Response to Submissions and Amendments to Proposed Development

Sydney International Convention, Exhibition and Entertainment Precinct (SICEEP)

Darling Square - South East Plot Mixed Use Residential Building

Submitted to Department of Planning and Environment
On Behalf of Lend Lease (Haymarket) Pty Ltd

1 ELEVATION North - Little Hay Street
1:100

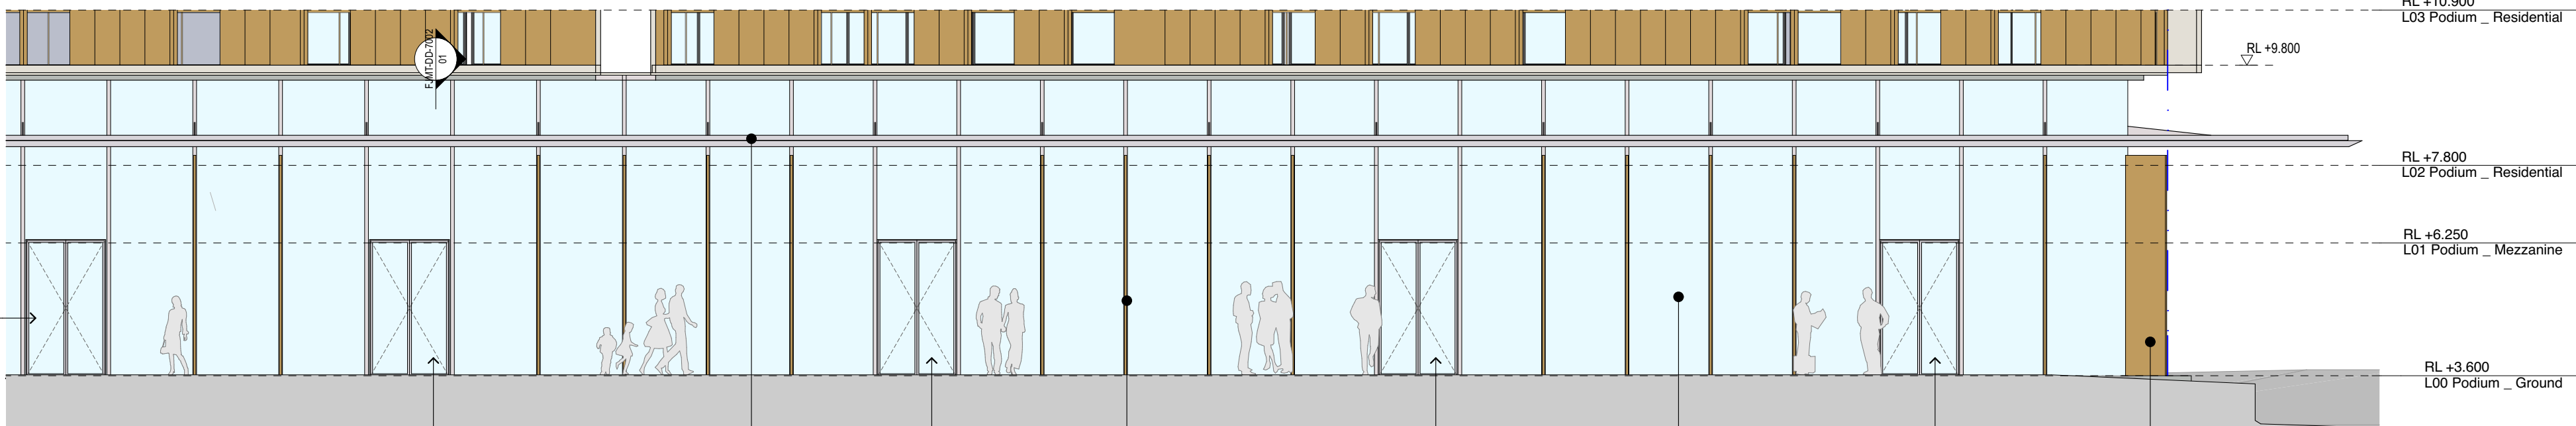
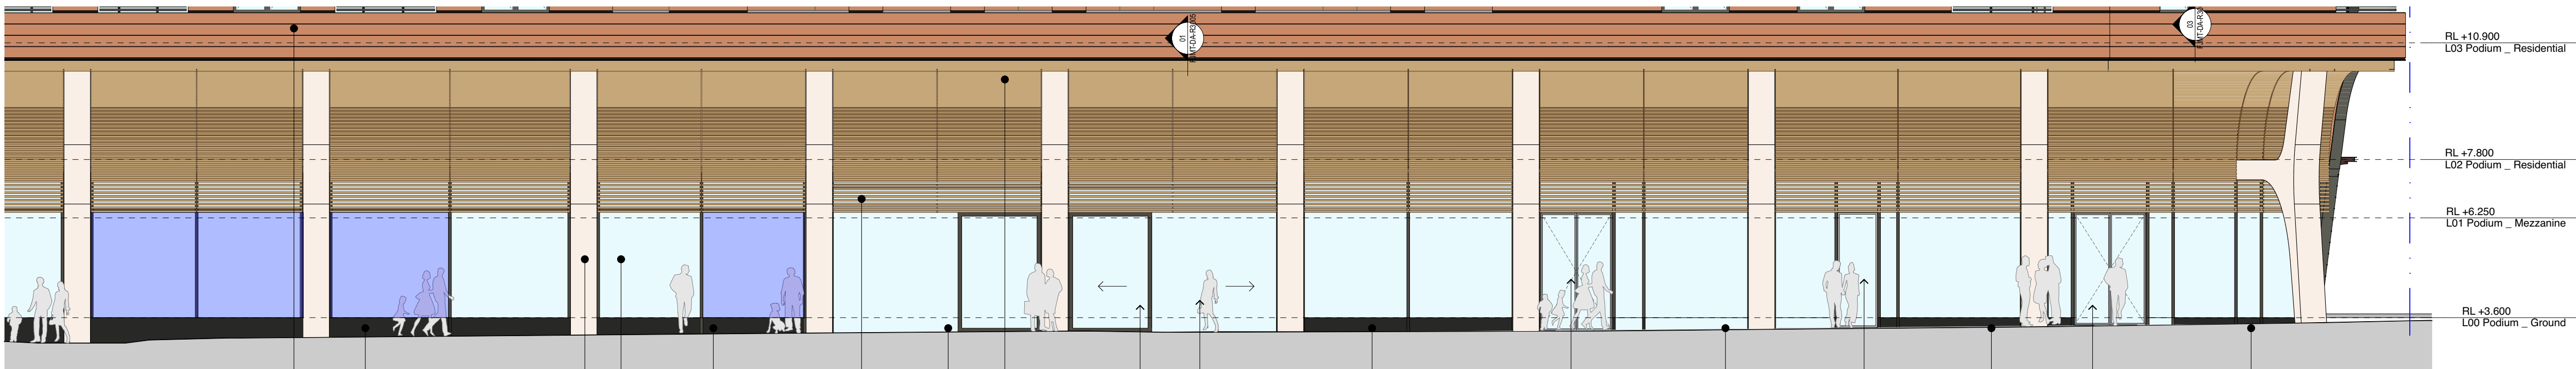
The Department has requested further information in relation to the screening which will be applied to the above ground car parking in the podium fronting Little Hay Street. Further details have been requested on the materiality of the screening and the suitability of the proposed landscaping. It has been requested by the Department that additional computer imagery is provided of the screening without landscaping.

Council also provided comments on the materiality of the above ground car park treatment. Additionally, Council provided commentary on the consistency of the proposal with the Stage 1 parameter plans.

The above ground car parking in the podium will be treated with louvres and aluminium (terracotta colour) battens. Detailed sections illustrating the details of this treatment are provided at **Appendix D**. *Trachelospermum jasminoides* (Star Jasmine) will be provided to the above ground parking, a plant known for being hardy, drought resistance and suited to planting on structure. Turf Landscape Architects (Turf) have confirmed that the proposed species is suitable to support the intended outcome and that the locational attributes of the space will allow for sufficient solar access and protection from adverse wind effects (refer to **Appendix E**).
